Comments in respect to surface water drainage. Please also note that these comments also deal with the conditions under P/35/20/DOC;

APPLICATION NO: P/37/20/DOC

Site Address: Land North of Summer Lane Pagham PO21 4NG

Description of Works: Approval of details reserved by condition imposed under ref P/70/19/RES relating to Condition Nos 3 - drainage strategy and 5 - pumping station design

Headwall SW-14

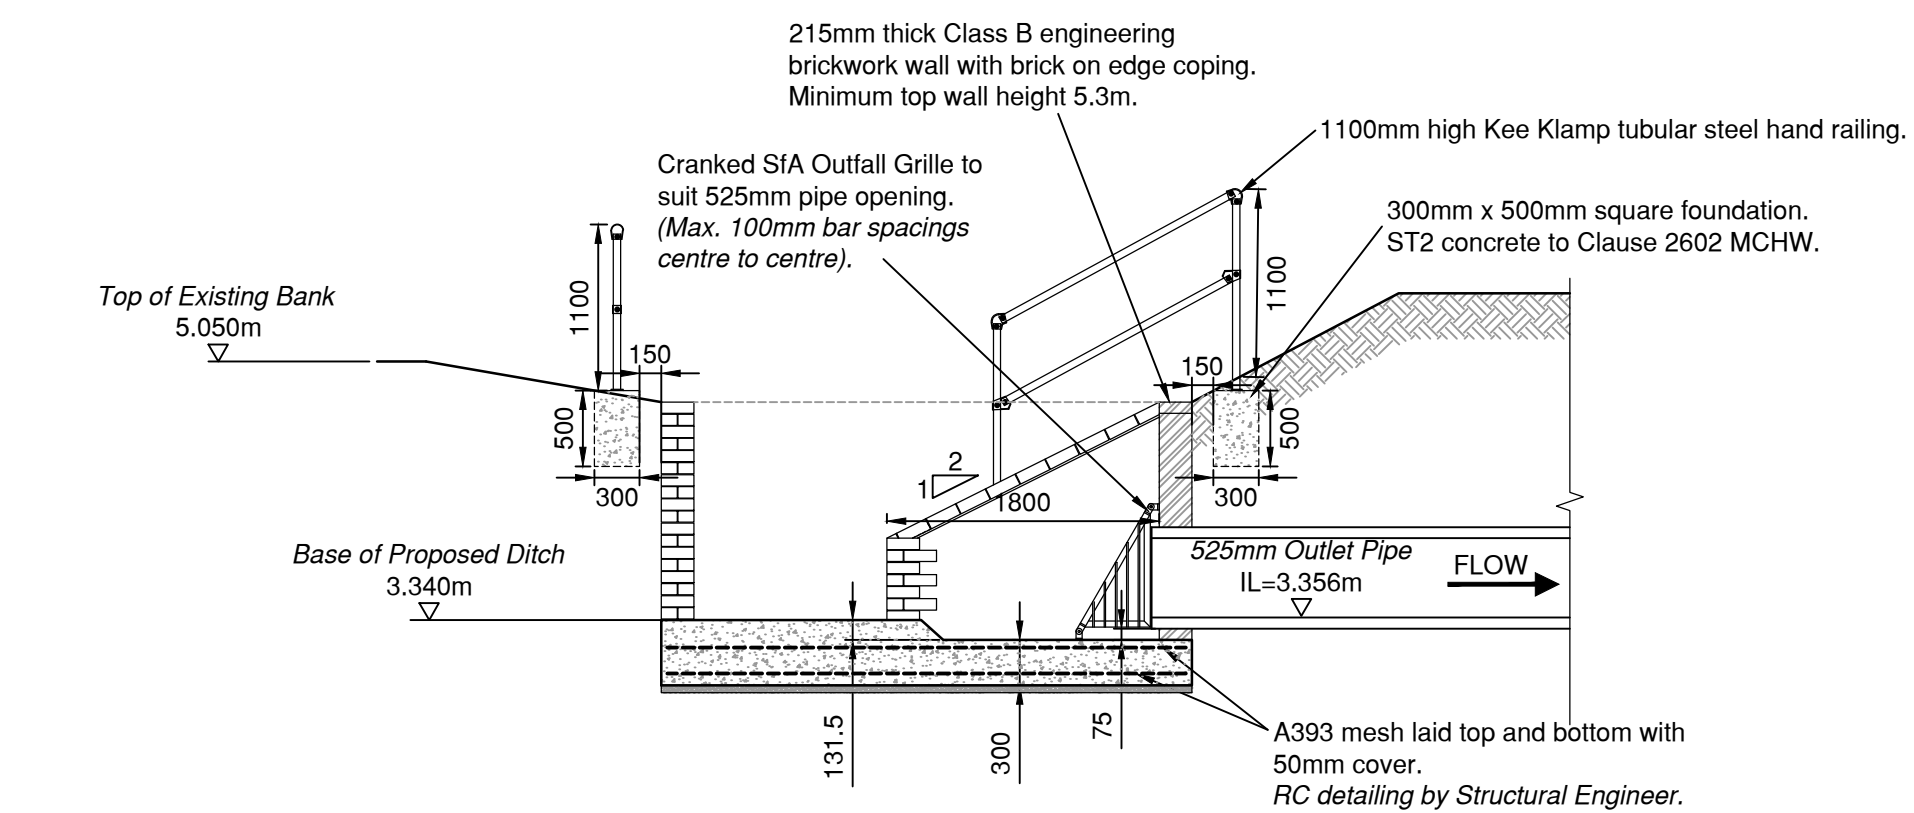
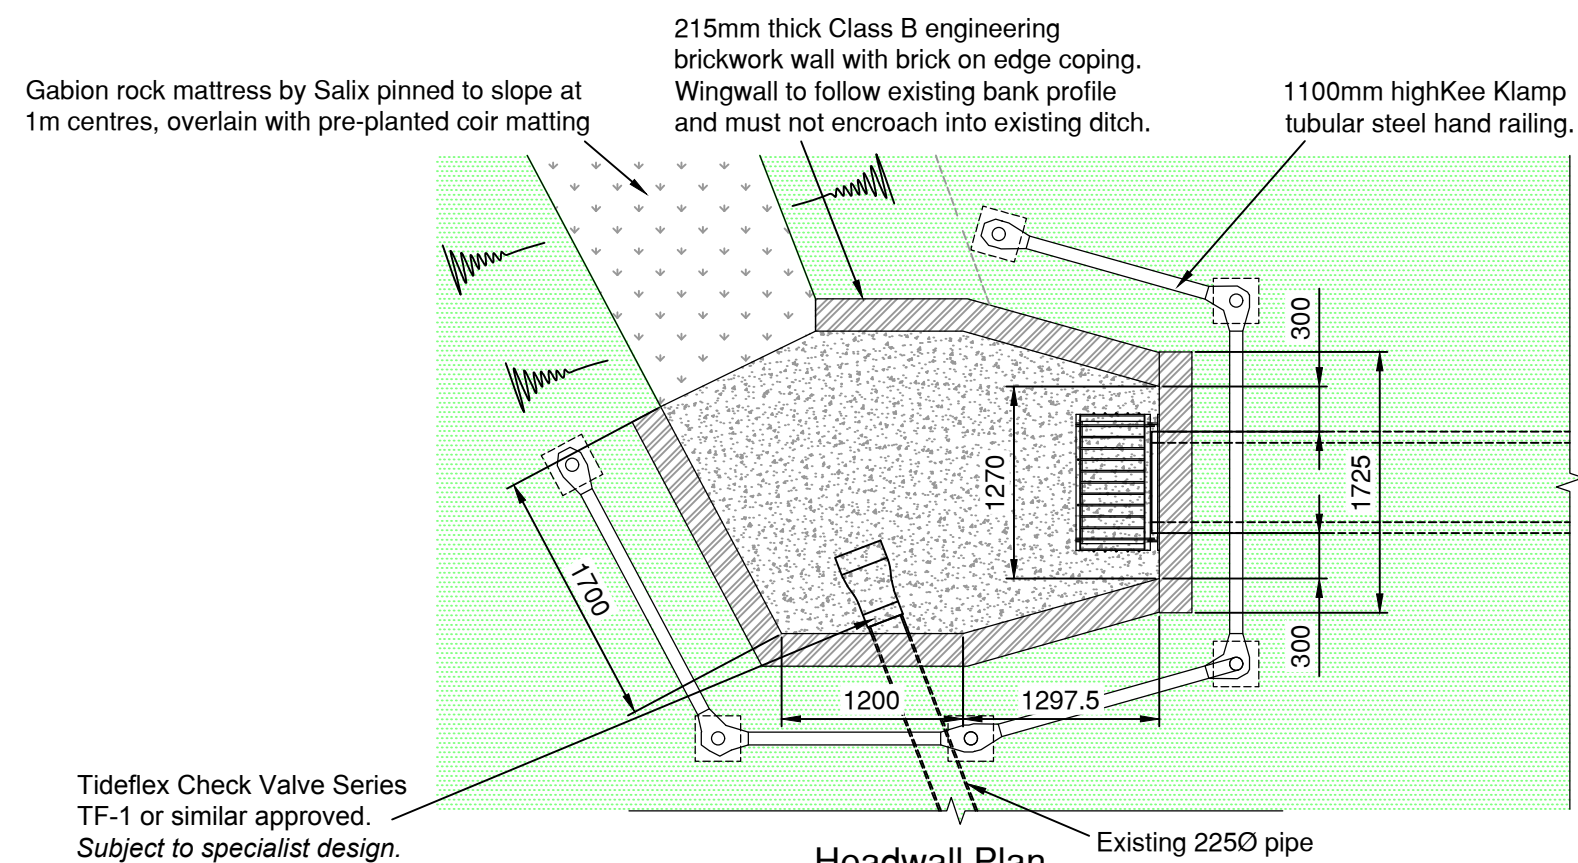
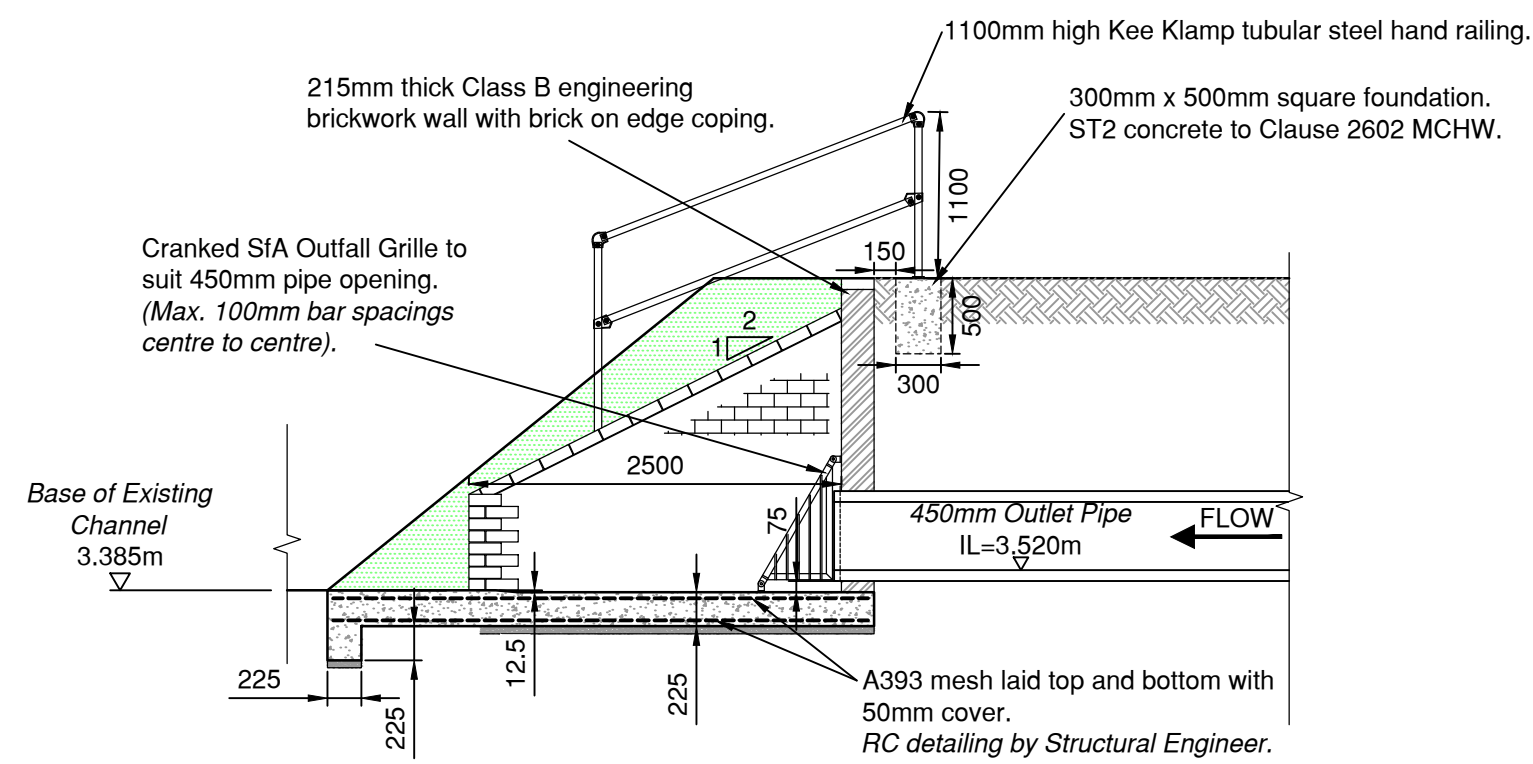
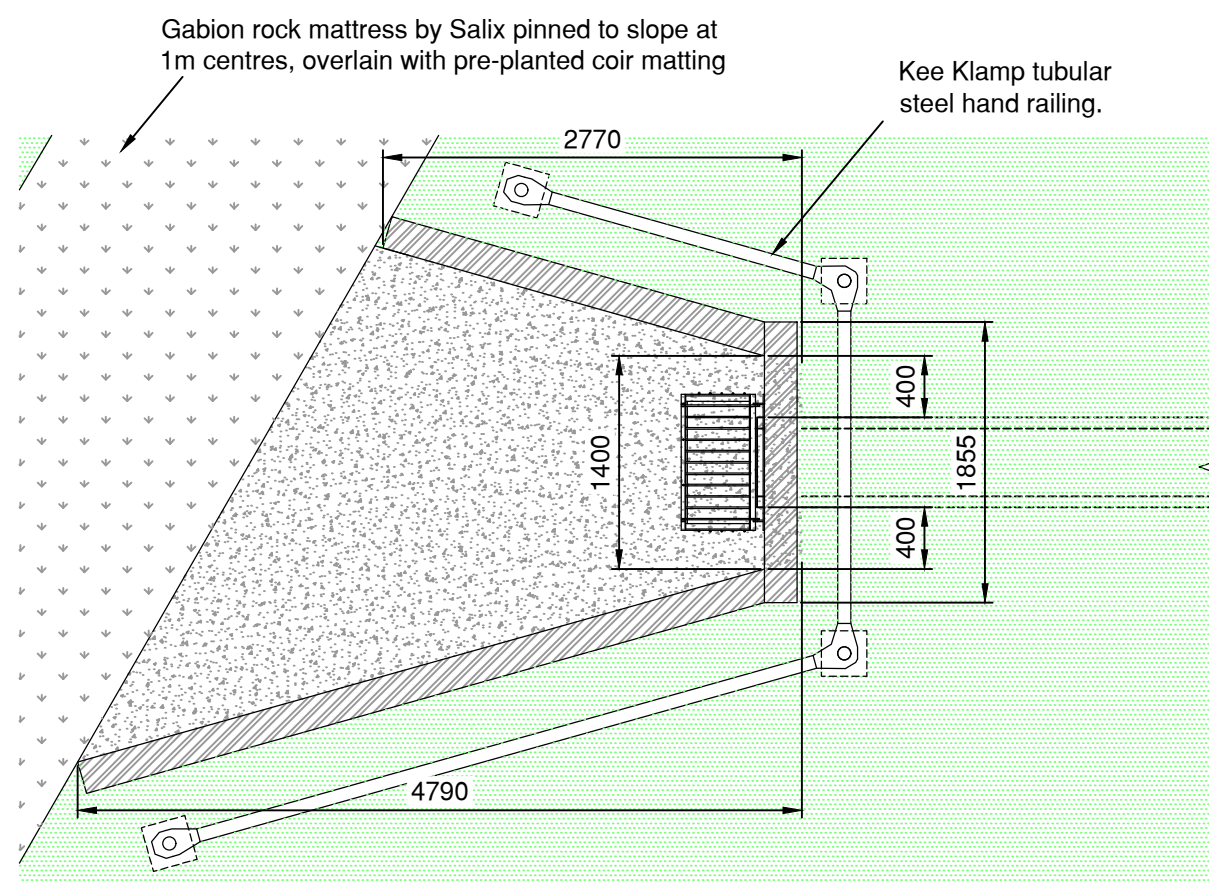
10. Provide construction detail for headwall SW-14.
11. Headwall SW-1 construction detail – remove grille. Indicate proposed ditch bed level , pipe invert level and diameter. Concrete capping to be ST4 or similar approved.
